Morgan Offshore Wind Project: Generation Assets

Relevant Representations of Natural England

Planning Inspectorate Reference: EN010136

10 July 2024

Viewpoint 44: Slieau Ruy Cairn, Isle of Man

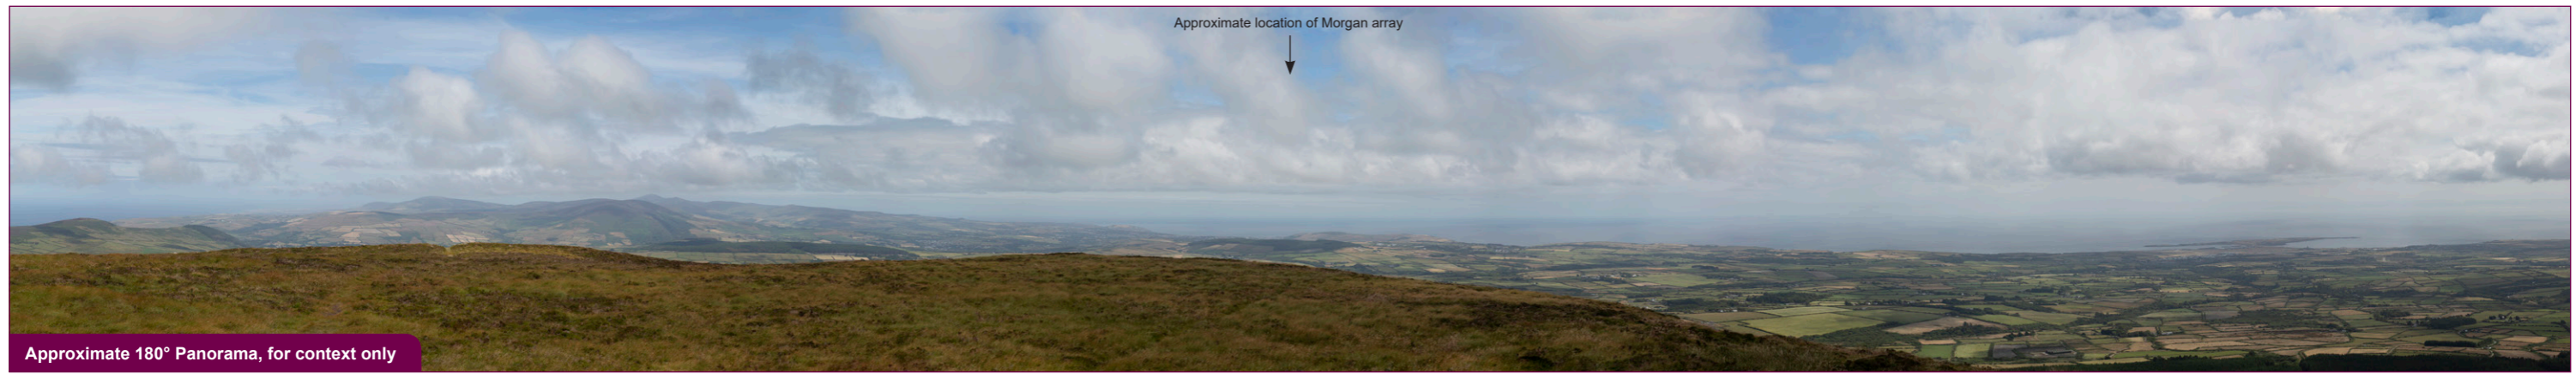
- **Seascape, Landscape and Visual Impact Assessment (SLVIA)** – Natural England has engaged with the Applicant and provided advice on SLVIA throughout the pre-application and Preliminary Environmental Information Report (PEIR). Natural England has no major remaining concerns on the impact the proposal will have on SLVIA receptors. However, there are some outstanding issues which we would expect to be updated and addressed in the final application as follows:
 - As advised at the PEIR stage, Natural England request that single frame images with a Horizontal Frame of View (HFoV) of 39.6° are included within the SLVIA for all viewpoints. Natural England also note that a couple of the images within the SLVIA documents still have issues with

sun glare obscuring the Wind Turbine Generator (WTG) representations (e.g. images for viewpoint 14 in document APP-039). Updated material should be submitted into the Examination in due course.
